View of western portal from the new A303 PRoW

Referring to [REP7-024] 8.47 OEMP Annex 4A – Illustrated Examples of Key Design Elements

Tunnel Western Portal Approach, item, 4.2.10 (a) *“The Scheme should maximise the concealment of structures and features outside of the tunnel from the wider landscape through their siting in the landscape in relation to existing ground levels”*

PROPOSED BORED TUNNEL - (WORK No. 1F)

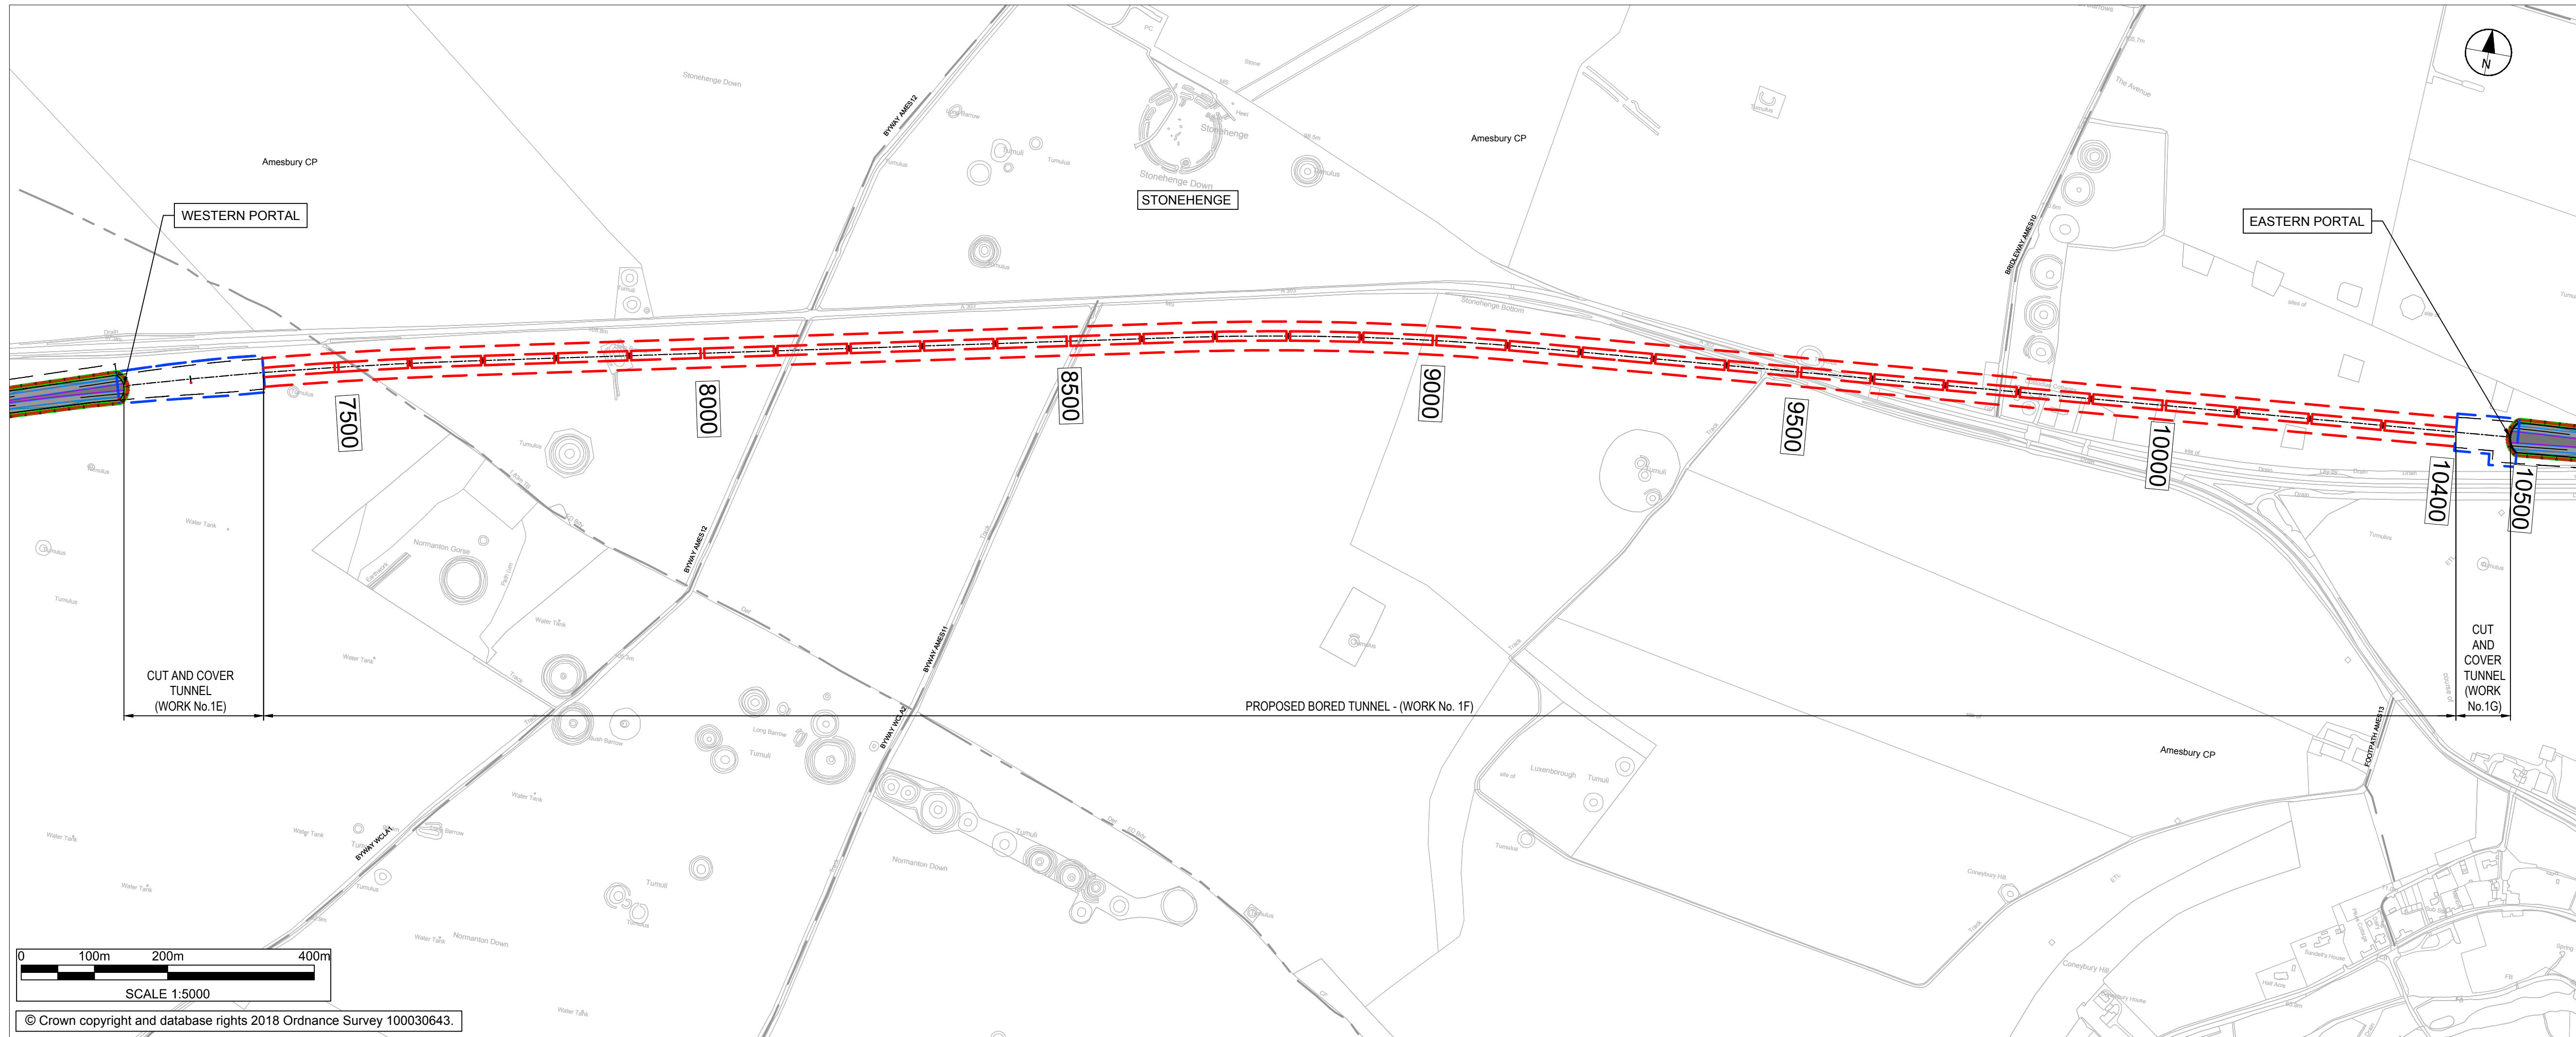
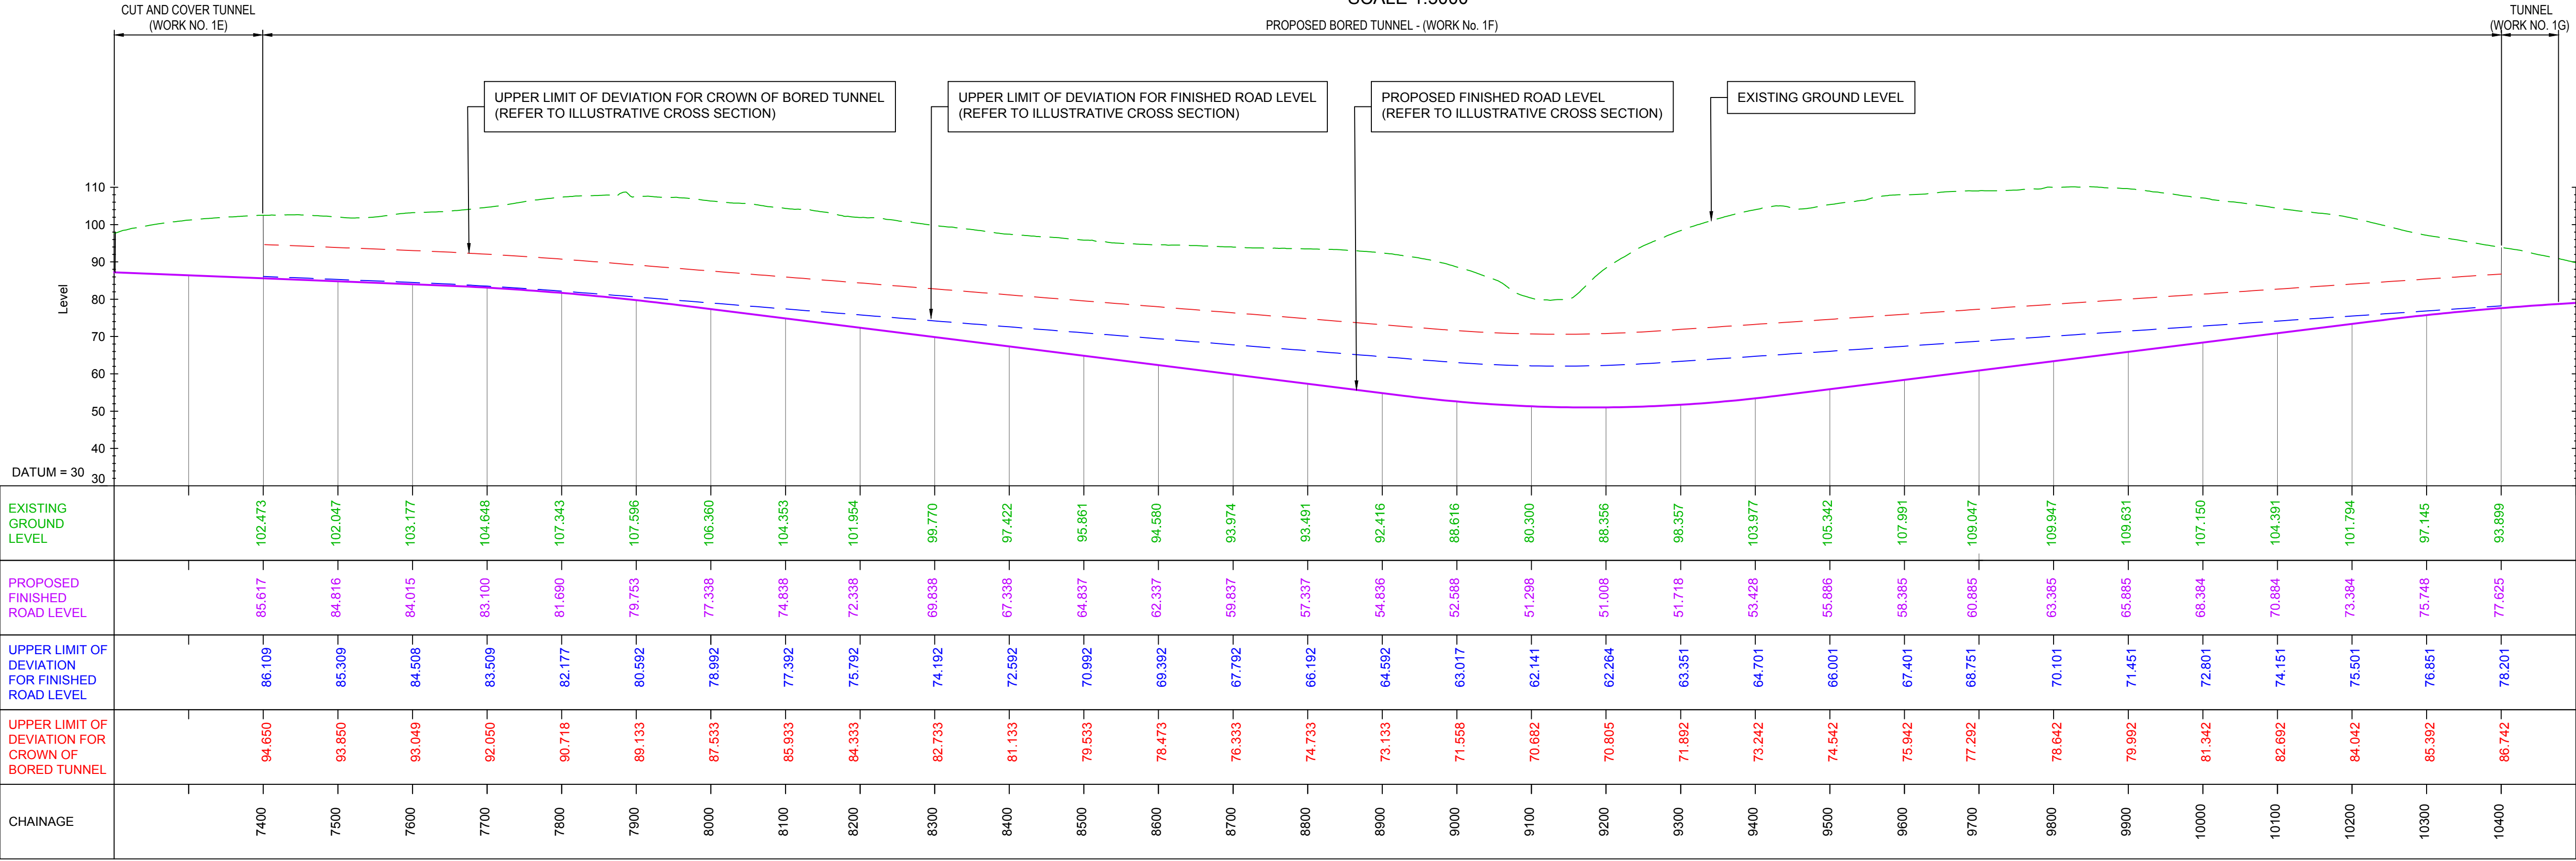
The Scheme as presented, has used the natural topography of the landscape, placing the road at the lowest point within the dry valley. However, it has not taken into consideration the topography in the location of the western portal, where the road level of the current A303 has been significantly built up from ground level in order to remove the blind dip in the road. See Fig 1. below showing the extent of the built up area of the A303.

We believe that from the new A303 PRoW, in the location of the western portal, there will be a view of both the portal and deep cutting. We have asked for photomontages from this location but the Applicant has not provided any. The only drawing produced from the A303 PRoW, has been from the layby next to Winterbourne Stoke Clump.

Travelling west along the verge (which will be part of the PRoW), look back to the east, there will be a view into the deep cutting which will certainly show the retaining walls. See photograph below fig 5 .

The photographs above clearly show that the design with the western portal and deep cutting within the WHS do not fall within the Scheme criteria as noted in a number of the OEMP items, eg:
